RE: CM/51/21/DOC

From: Maria Tomalova <Maria.Tomalova@arun.gov.uk>
Sent: 01 November 2021 17:26
To: Martyn White <Martyn.White@arun.gov.uk>
Subject: CM/51/21/DOC

Condition 2: Details of any new or replacement windows and doors including the material, decorative/protective finish, glazing, cross section of frame, glazing bars shall be submitted to and approved by the Local Planning Authority prior to installation and the development shall proceed in accordance with the details so approved.

Drawing Title
**WINDOW AND DOOR
DETAILS**

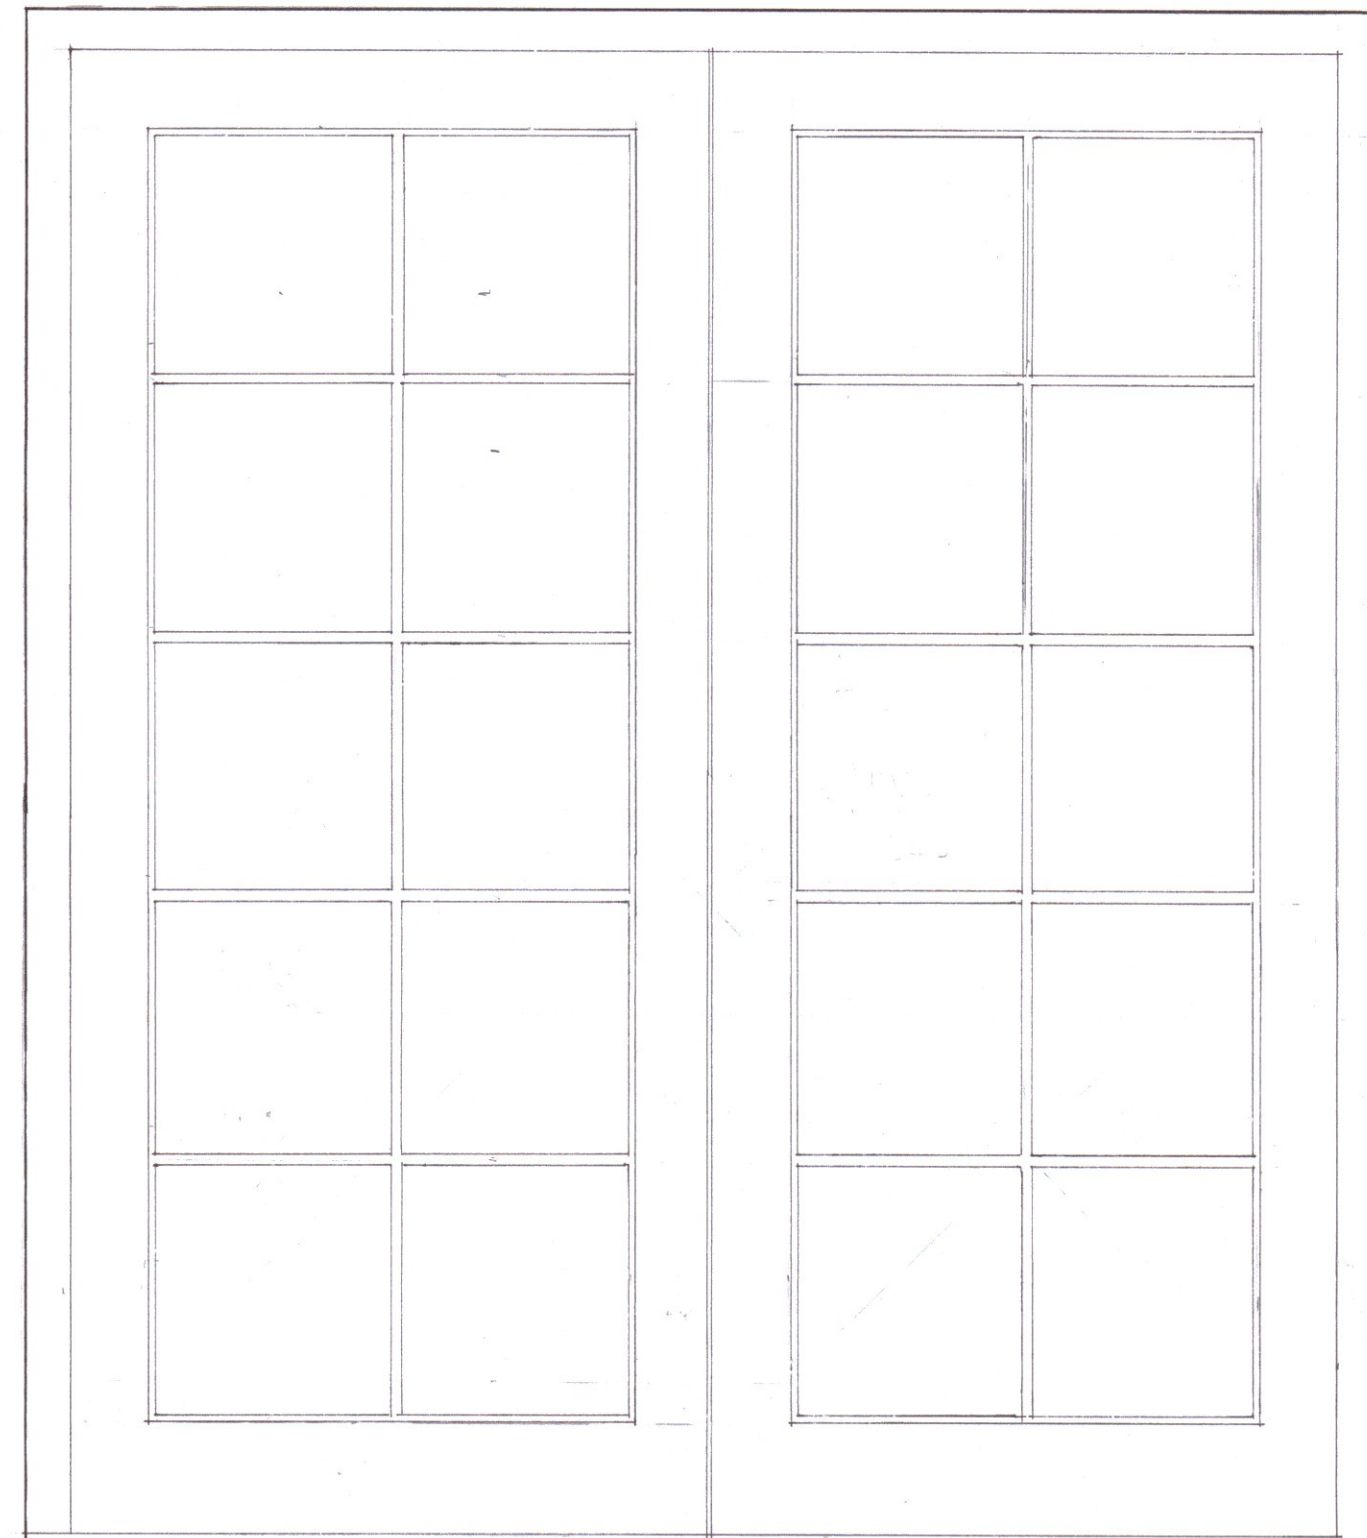
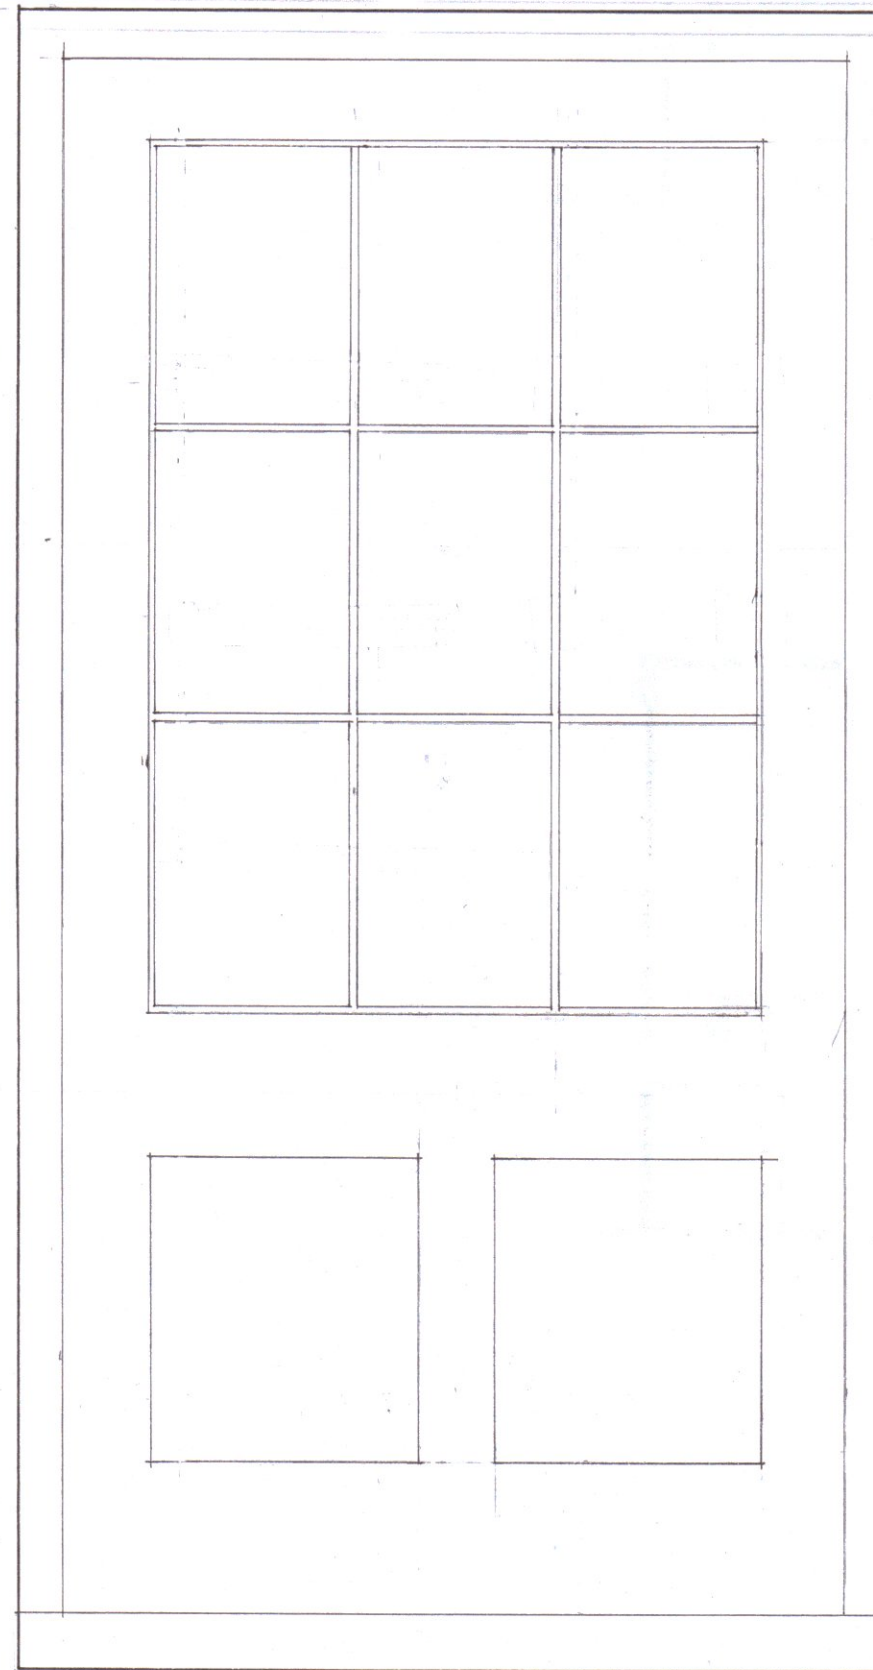
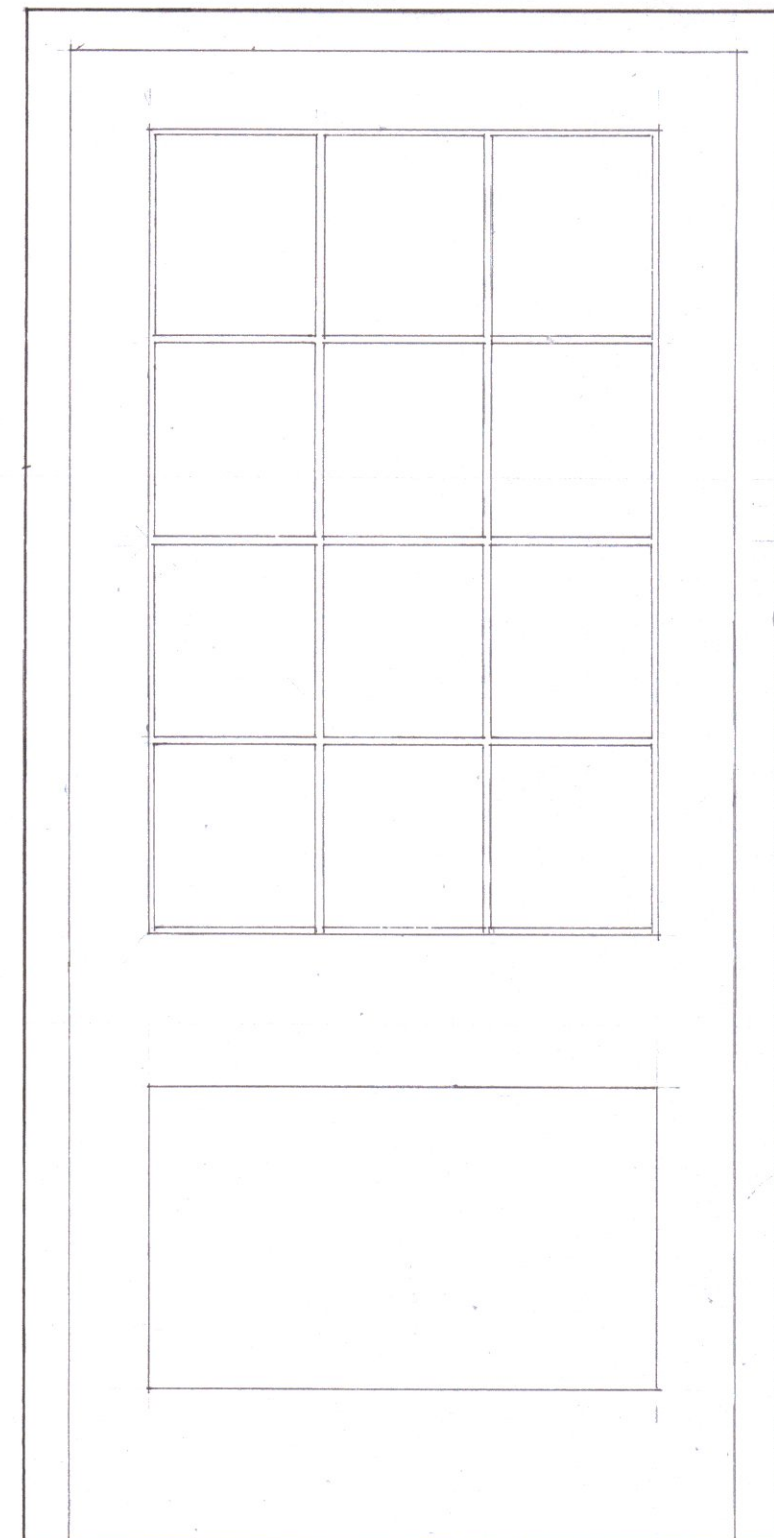
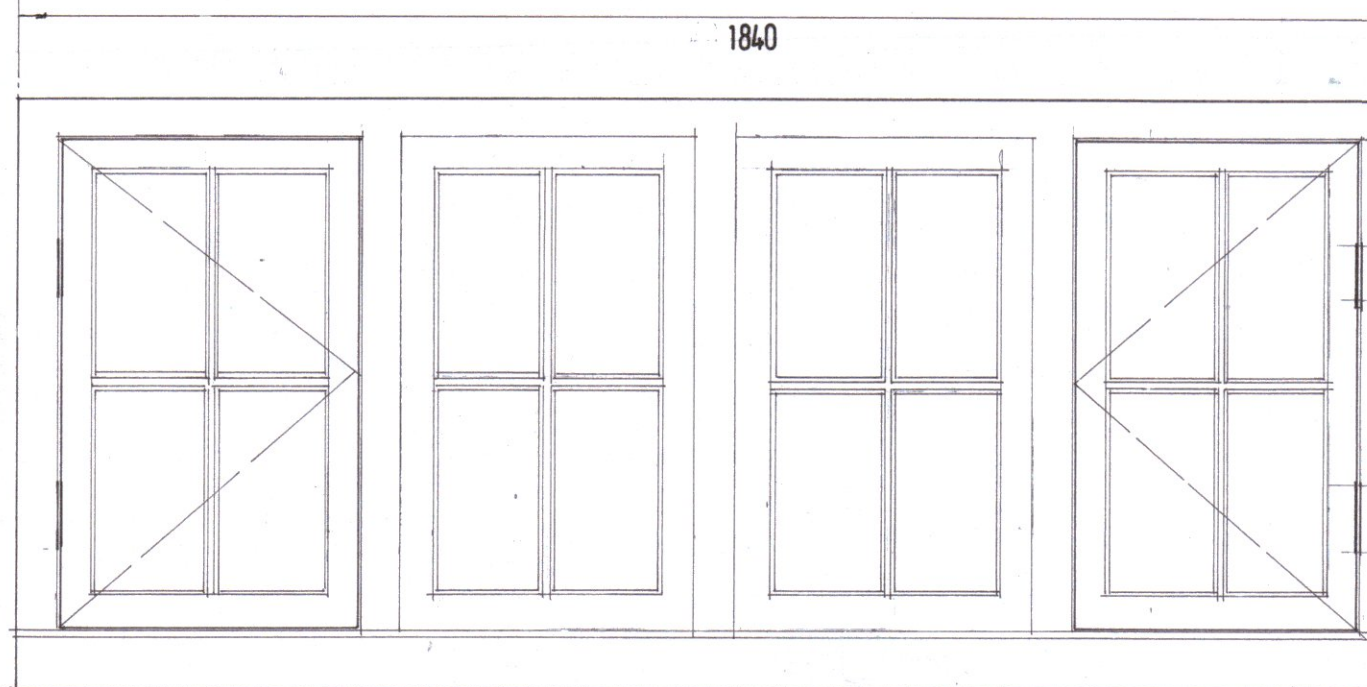
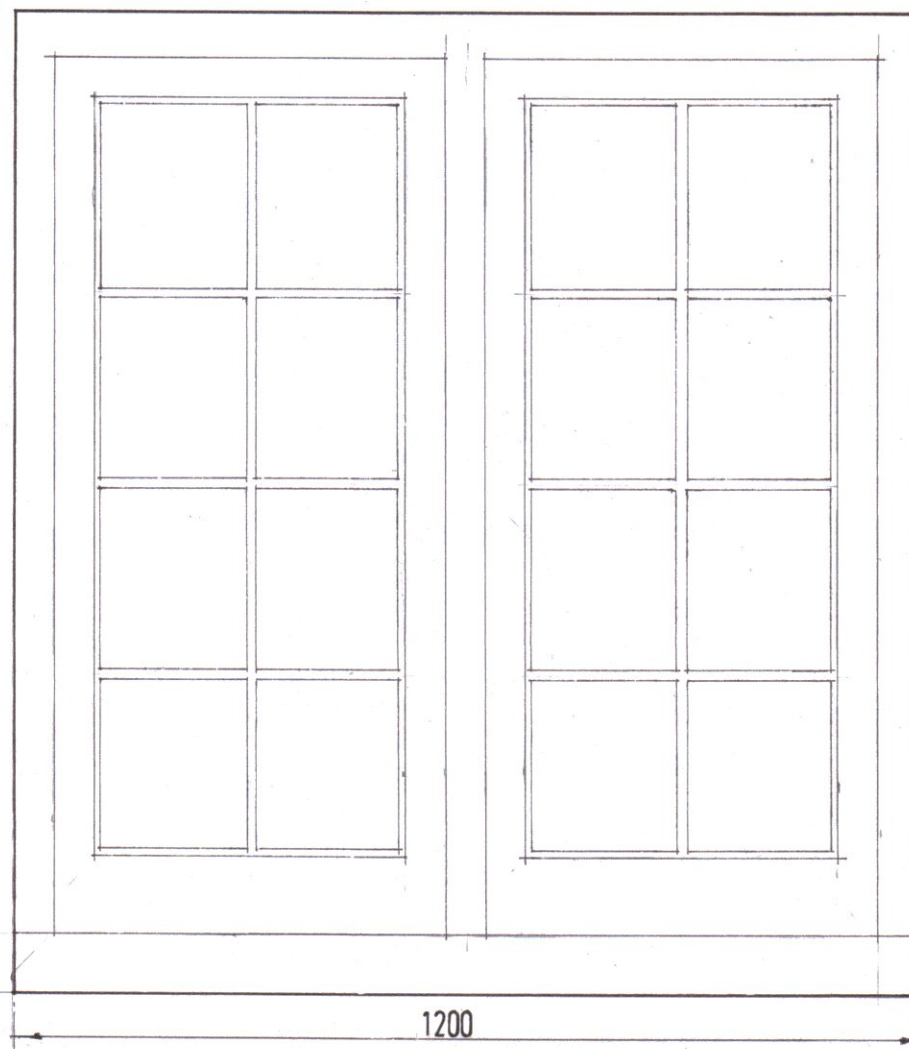
So it sounds like they intend for the new windows and doors to match the existing ones in terms of appearance, paint colour and glazing bars, with the slimmer double glazing. The latter being acceptable as it relates to specific units and not the entire building. overall the windows sound acceptable

The drawing for the window sections has come from the joinery company, but they have been instructed following the Discharge of this Condition that all window glazing must be the 4 x 4 x 4 design and not 24mm

The window bars are to be a match to the glazing bars elsewhere in the house they **are to** frame up each pane of glass i.e. not applied or stuck on imitation glazing bars

In summary the windows, doors and their various sections are to match the period of the house.
